**METHODIST LADIES COLLEGE – SSD 6484 MOD 1  
45 PARK ROAD, BURWOOD**

The modification application (SSD 6484 MOD 1) for the MLC Senior School Campus was publicly exhibited between 2 November and 15 November 2016.

In an email dated 24 November 2016, Burwood Council has questioned whether the proposed modification can be considered substantially the same development, and has raised some concerns regarding the proposed variation to the height and floor space standards contained in *Burwood Local Environmental Plan 2012* (BLEP 2012). This letter sets out the proponent's response to these matters. At the Department's request, this response focuses on Council's comments relating to substantially the same development. This response should be read in conjunction with the attached legal advice prepared by Addisons.

SCALE @ A1

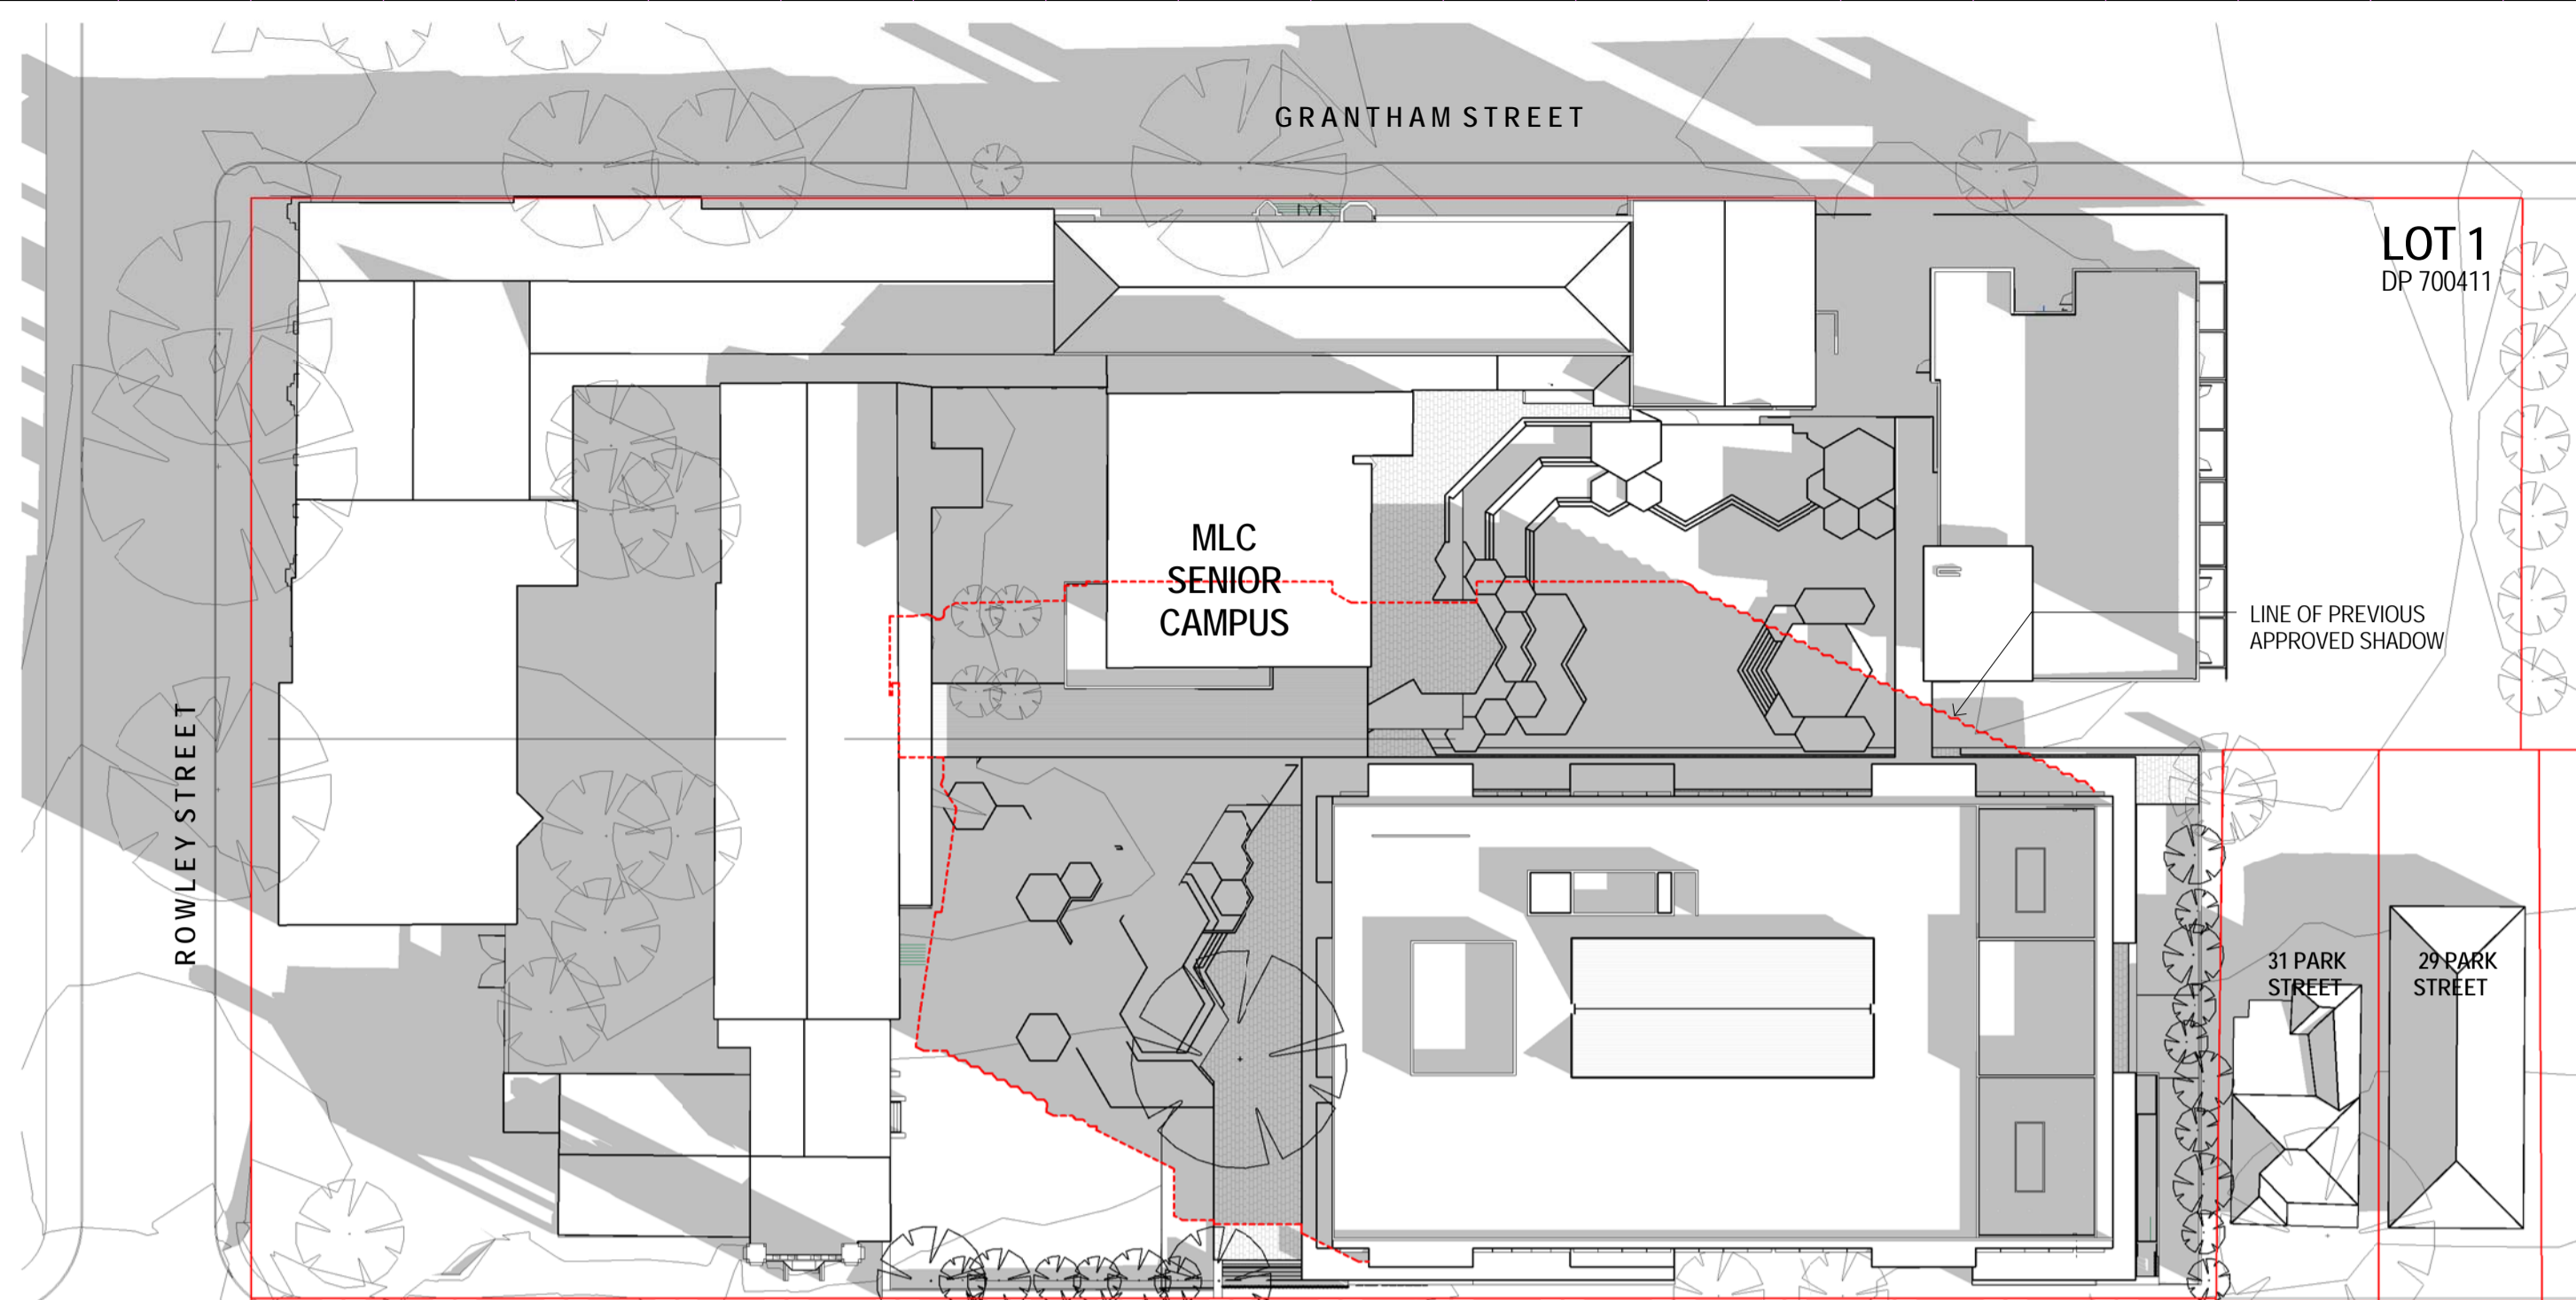
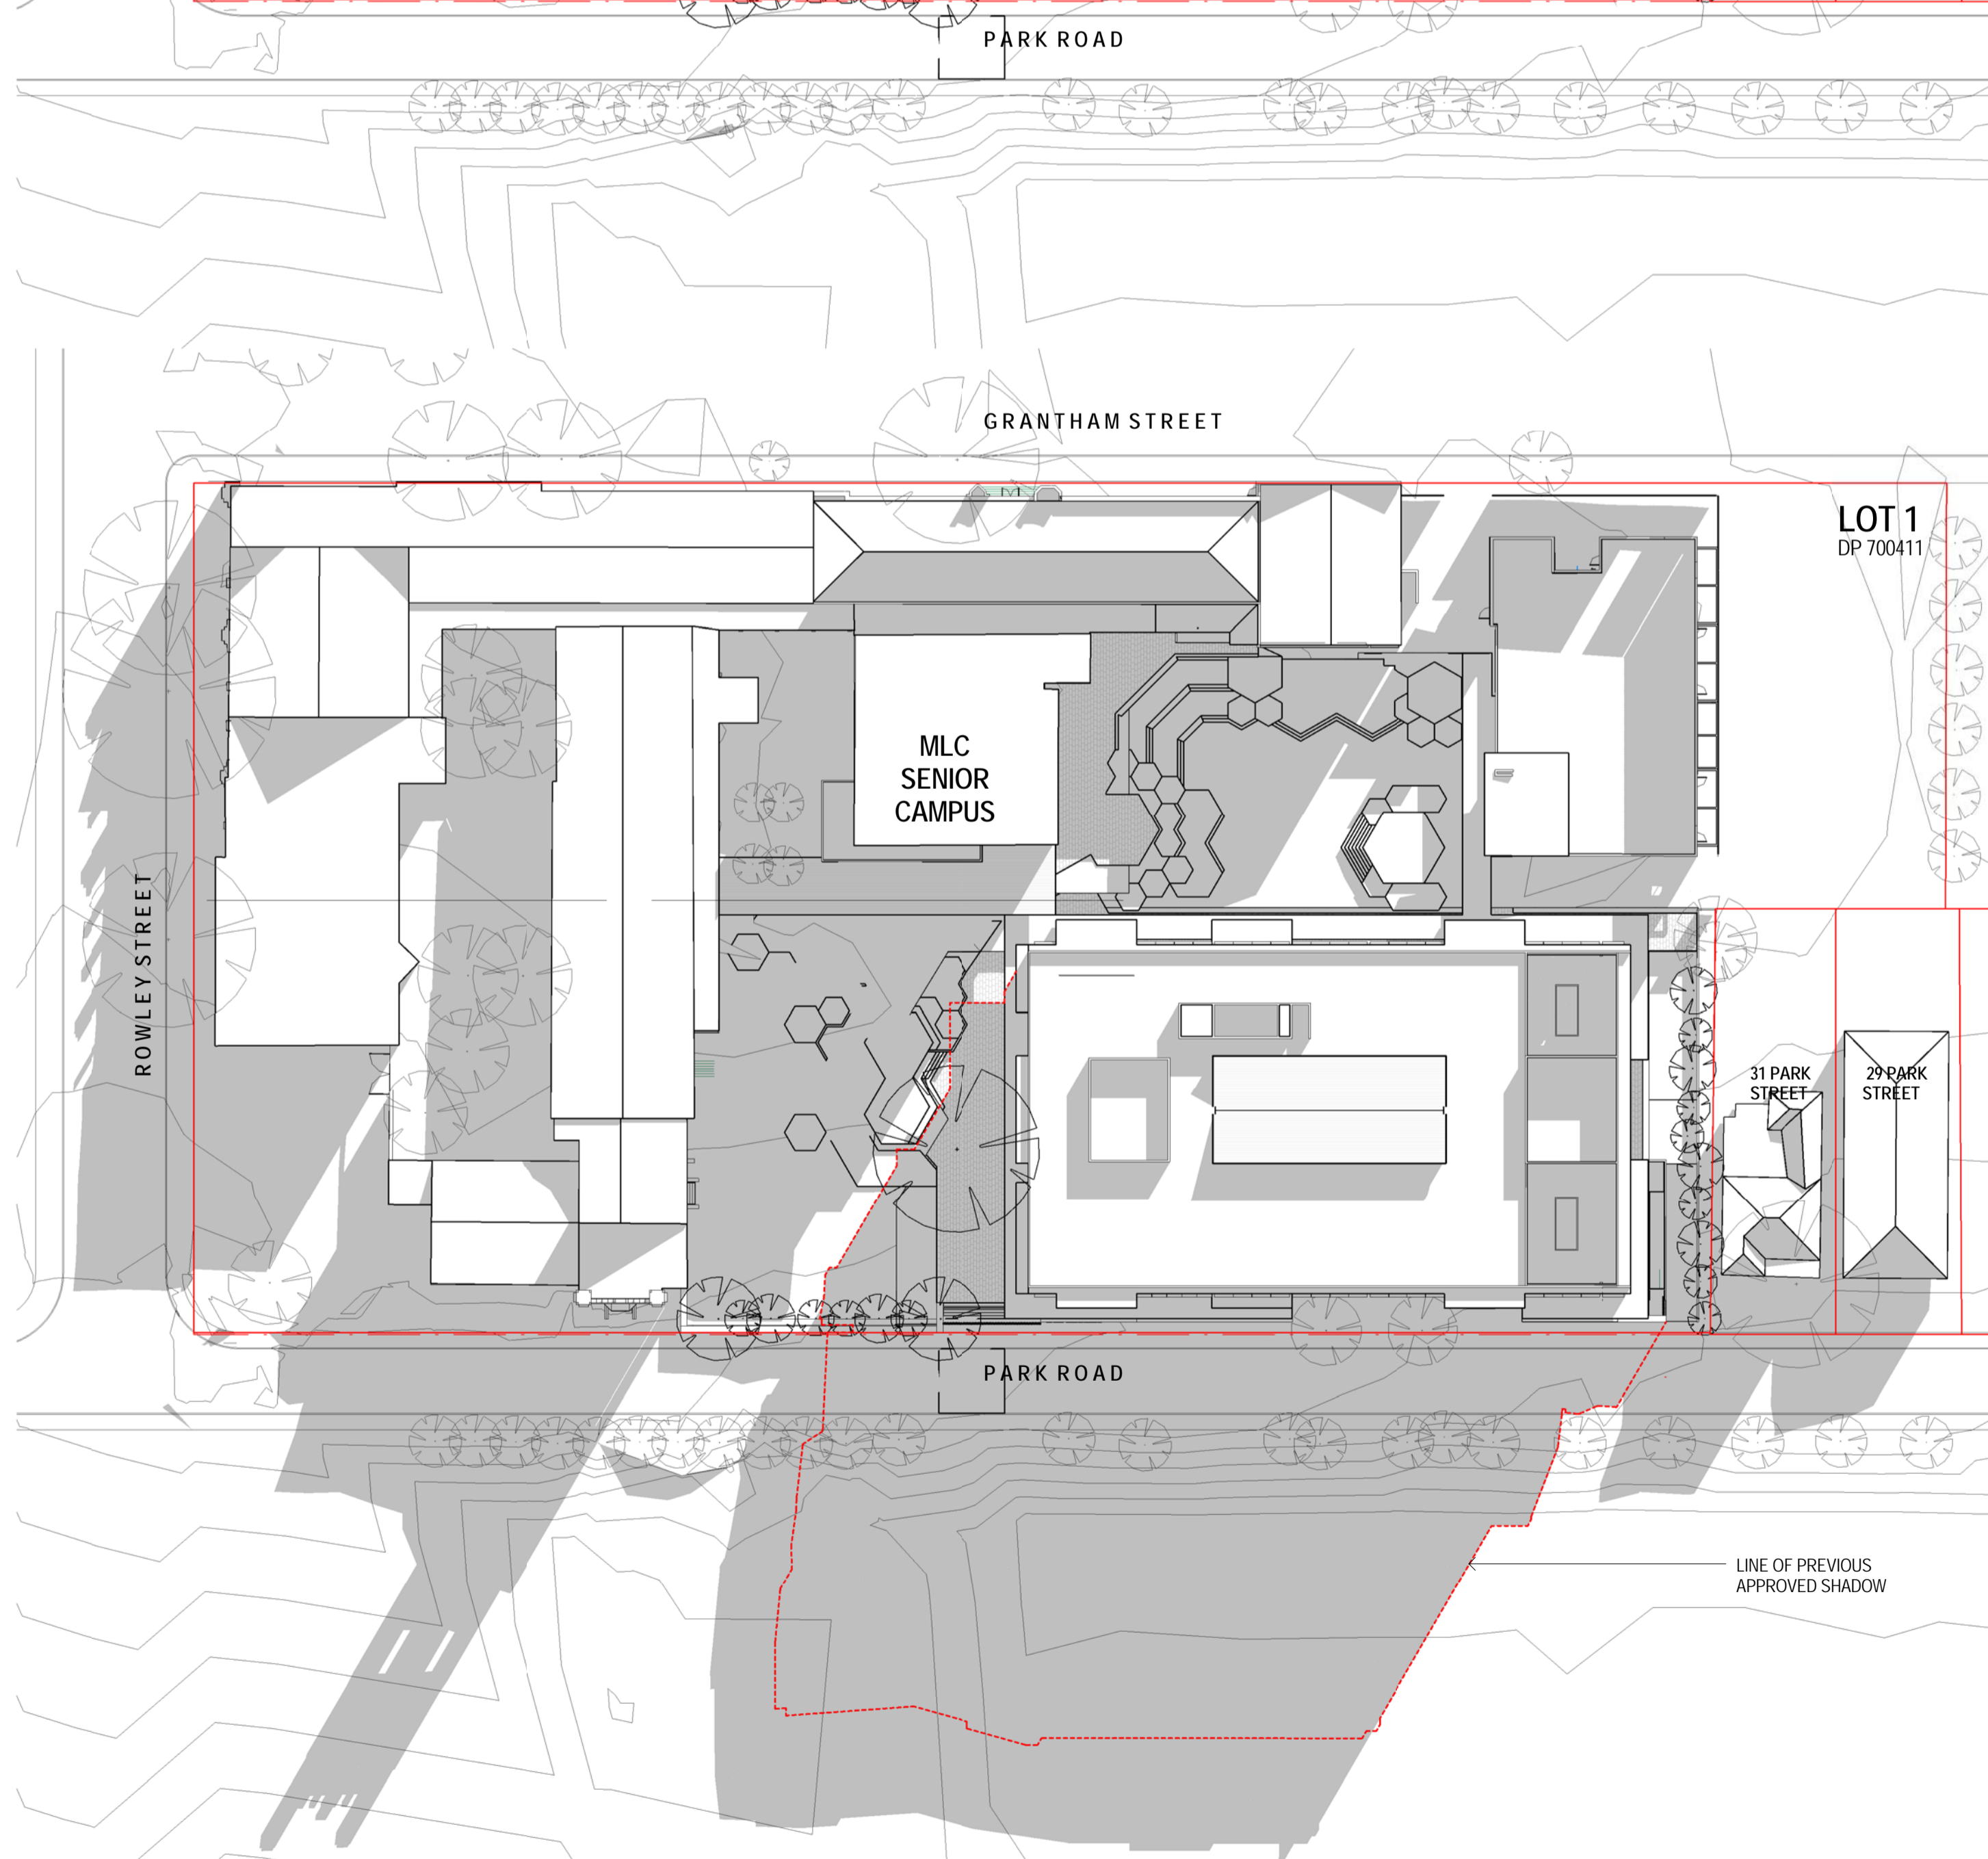
**The impacts from the proposed scale of the development are considered to result in substantial changes to shadow impacts. The proposed outdoor learning area on the upper storey also has the potential to reduce aural privacy of surrounding developments.**

The proposed change to the building envelope of the Teaching and Learning Building results in shadow impacts that are minor in nature. As shown in the Revised Architectural Plans at Attachment A of the modification application, the additional shadow impacts to the south occur only in the late afternoon from 3pm onwards on the summer and winter solstice, with all additional shadow impacting the school's tennis courts. Due to the limited duration of the overshadowing and the absence of any impacts on private property, the impacts can reasonably be considered to be minor in nature.
